Response to Agency and Public Submissions

Dargues Gold Mine

Modification 2

September 2013

Figure 3
APPROVED PROJECT SITE LAYOUT

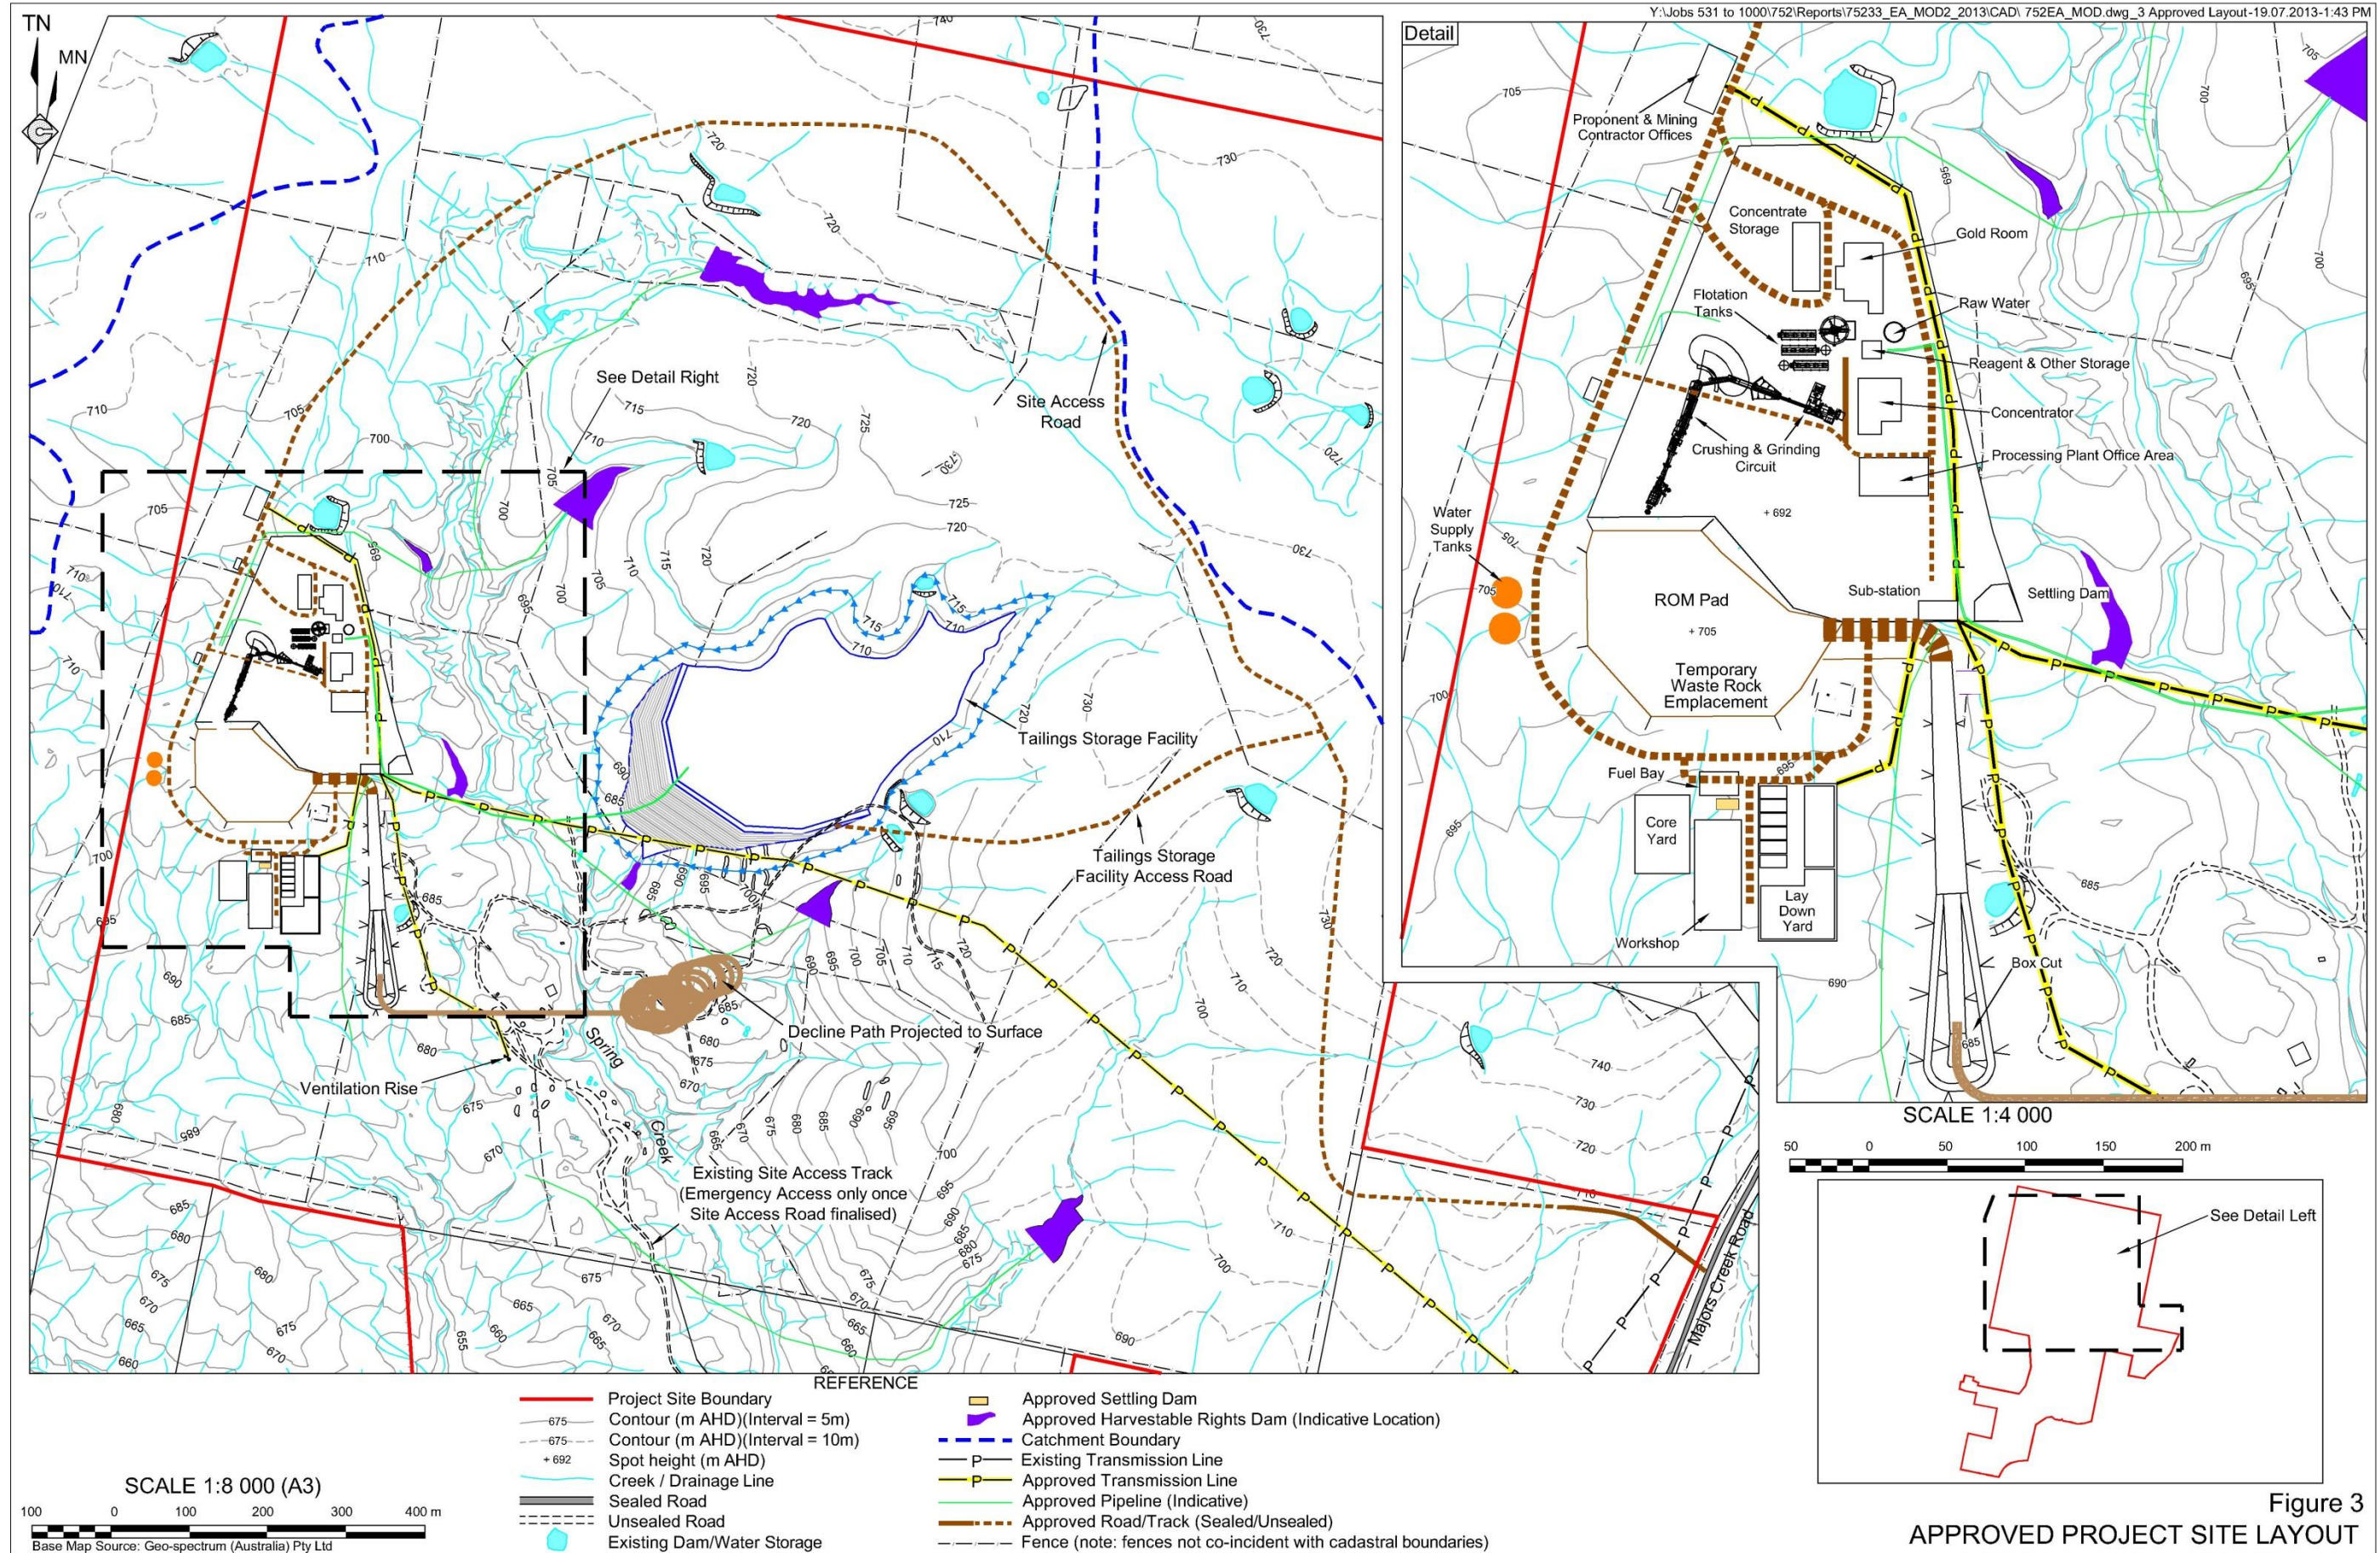
- iii) *It is noted the drainage layout in the Water Management Plan (January 2013) indicates a different design for the clean water diversion than the approved or proposed site layout in Figures 3 and 5 of the EA. It is expected this would be one of the revisions required to the Water Management Plan.*

The Proponent acknowledges the request by NSW Office of Water that the *Water Management Plan* be reviewed and revised as appropriate in consultation with the NSW Office of Water following determination of the application. The Proponent notes that such a review and revision is a requirement of Conditions 3(26) to 3(31) of MP10_0054 and that the matters identified in item v) would be addressed during such a review and revision. That review is required under Condition 5(4) to be complete within three months of granting of approval for the proposed modification.

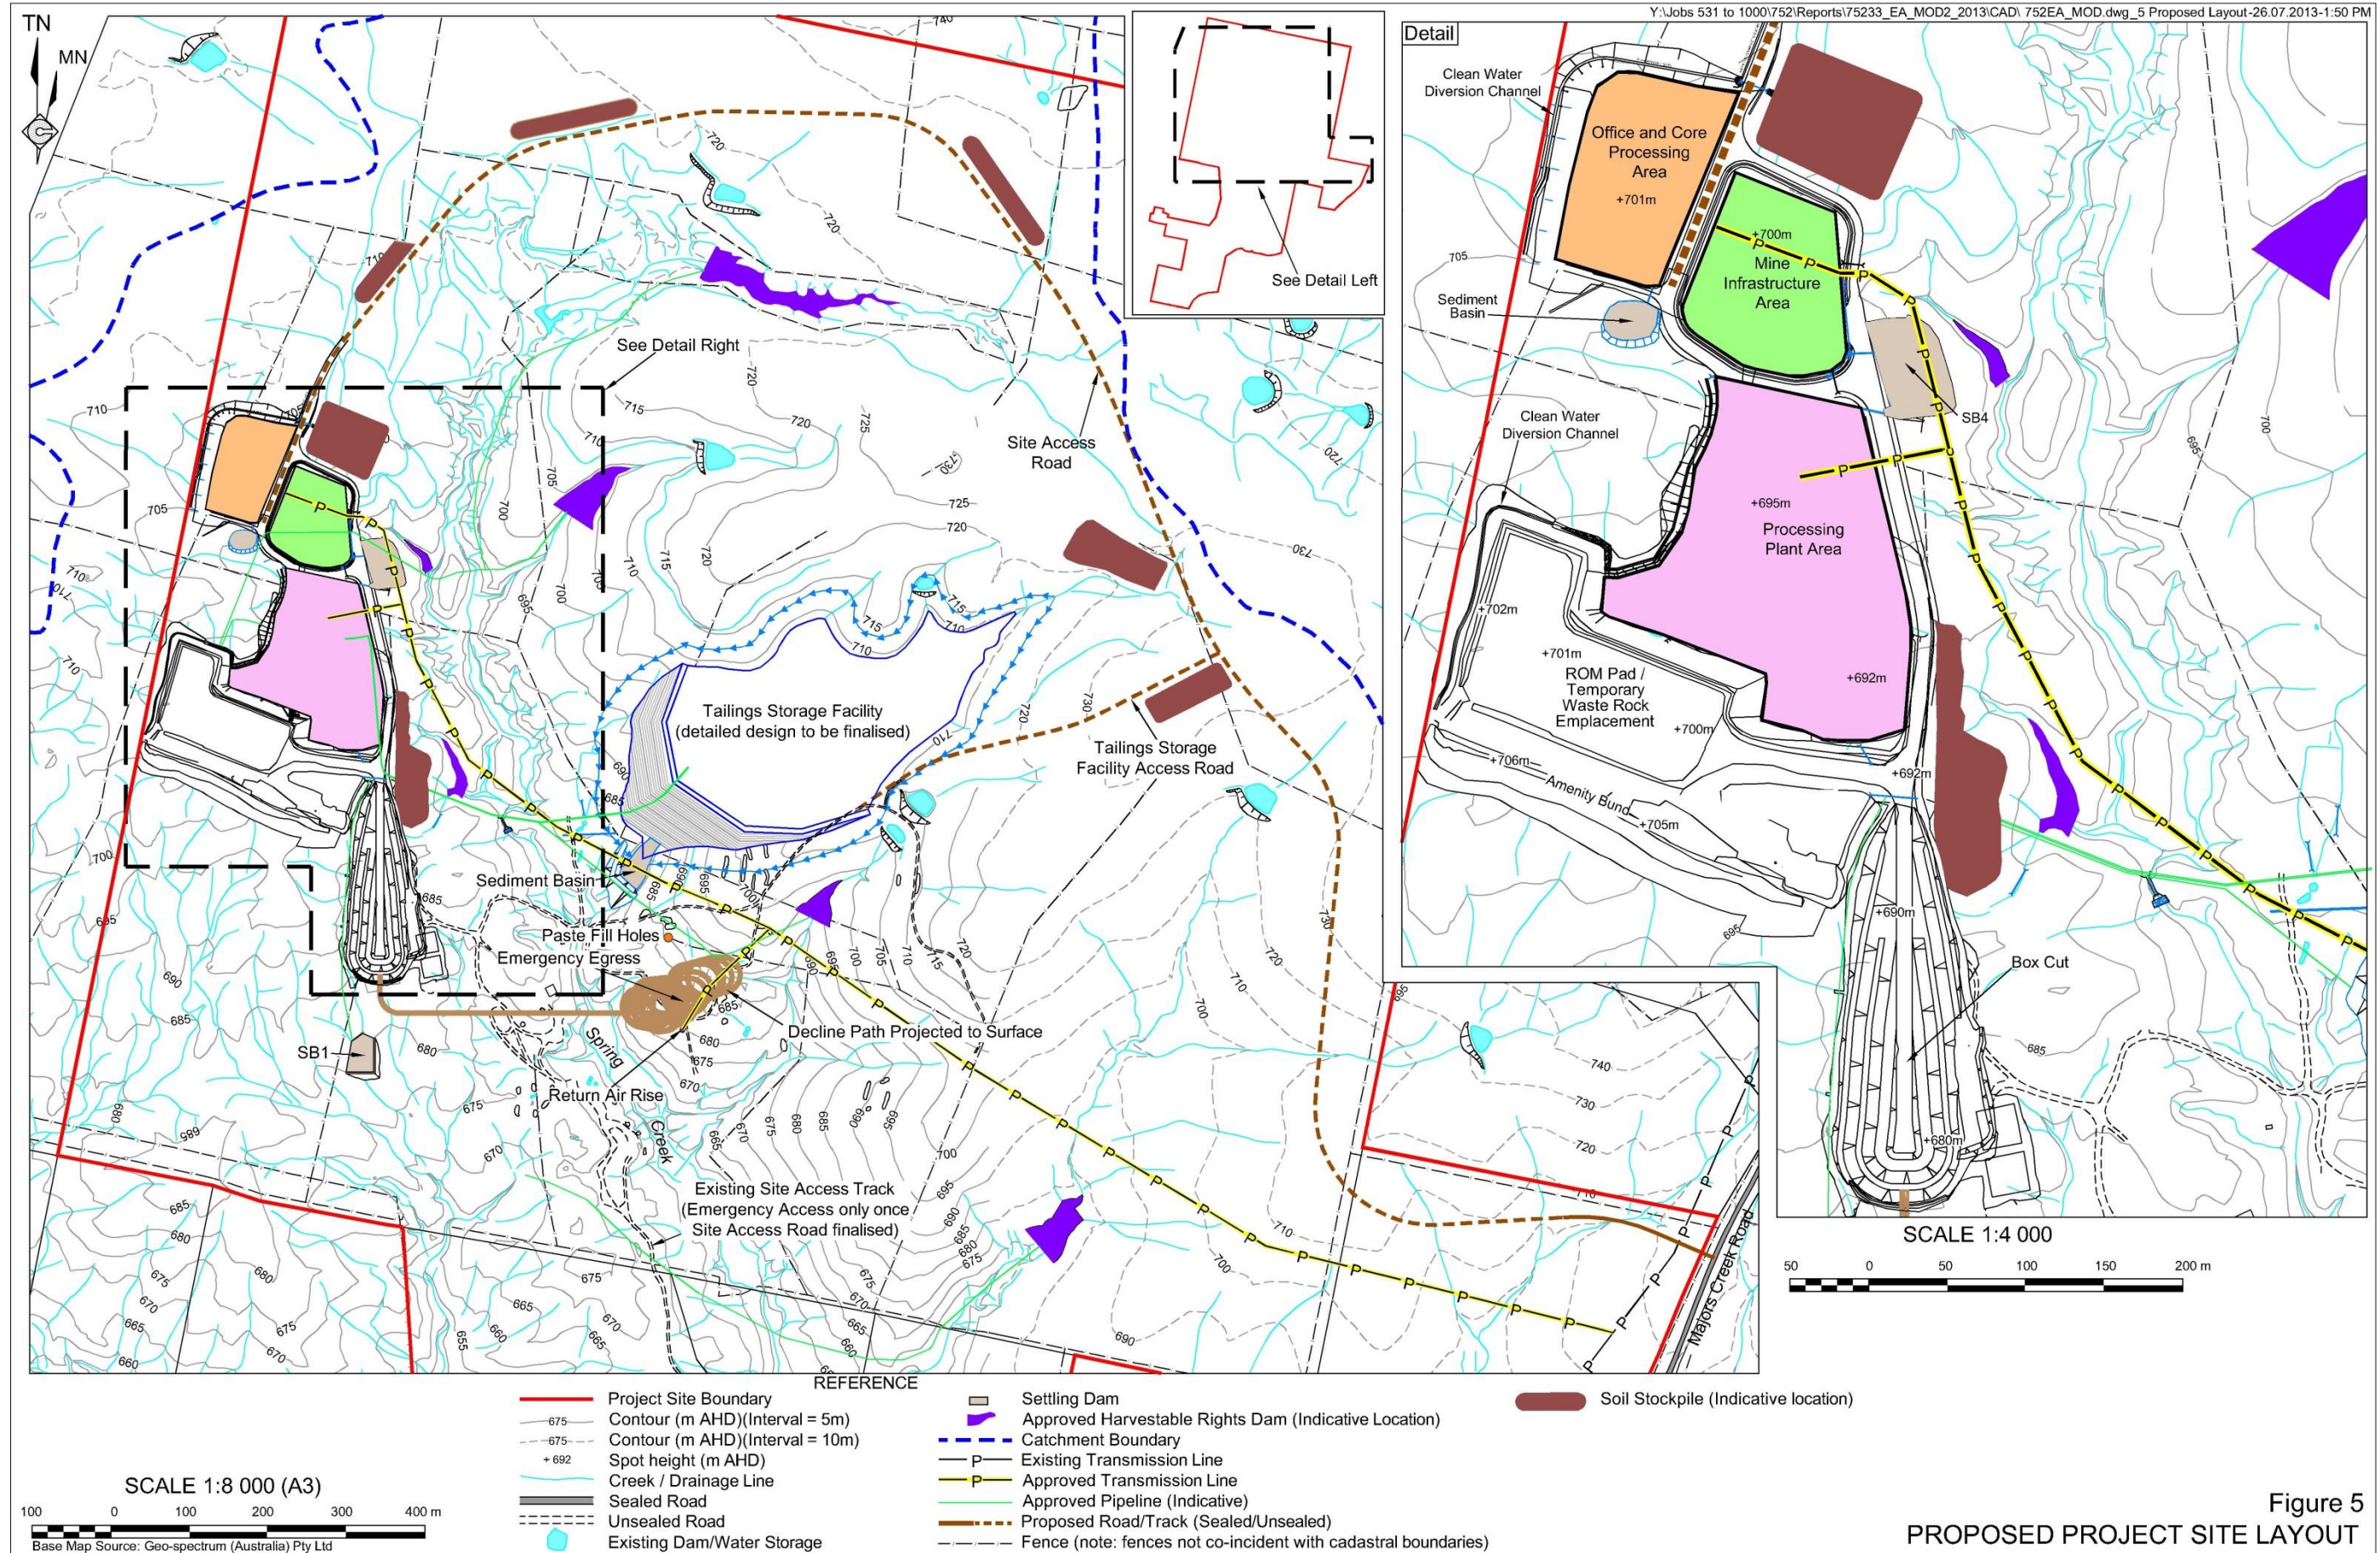
- i) *The modification proposal indicates the requirement to amend the surface water management system in terms of sediment basins and settlement dams. Clarification is requested as to the consistency of these amendments with the Maximum Harvestable Rights Dam Capacity. Of particular interest is the sediment basin at the base of the Tailing Storage Facility (TSF) which was previously the location of Dam F and is to capture water via the clean water diversion.*
- ii) *Clarification is requested on the interaction of water collection between the sediment basin at the base of the TSF and the seepage collection pond. Figure 5 in the Environmental Assessment (EA) shows no distinction between the two storages, hence uncertainty exists in the management of clean and contaminated water at this location.*

The Proponent acknowledges that Figure 5 of the *RWC (2013)* identifies that the dam located immediately below the base of the Tailings Storage Facility embankment and is labelled as a "Sediment Basin." The figure also shows clean water diversions discharging into the dam. This dam was previously identified on Figure 2.3 of the *Environmental Assessment* for the original application as "Harvestable Rights Dam F."

In light of the above, **Figure 1** presents a revised version of Figure 5 of the RWC (2013) showing:

- the label for the dam adjusted to “Sediment Basin/Seepage Collection Pond”; and
- clean water diversions discharging below the dam.

The Sediment Basin/Seepage Collection Pond would not form a component of the harvestable right dam network within the Project Site and water collected within the dam would not be used for the compensatory flow program. In light of this, the volume of the remaining harvestable rights dams would be increased slightly to ensure that the Proponent’s full harvestable right may be utilised, thereby allowing for the maximum amount of water to be available for use as compensatory flow. **Table 3** presents the anticipated adjusted volumes for the remaining dams. Given that the differential between the original and adjusted volumes for each dam is less than 10%, the Proponent anticipates that the approved area for each dam is sufficient for the increased volume and that the original water balance modelling for the compensatory flow program remains valid.
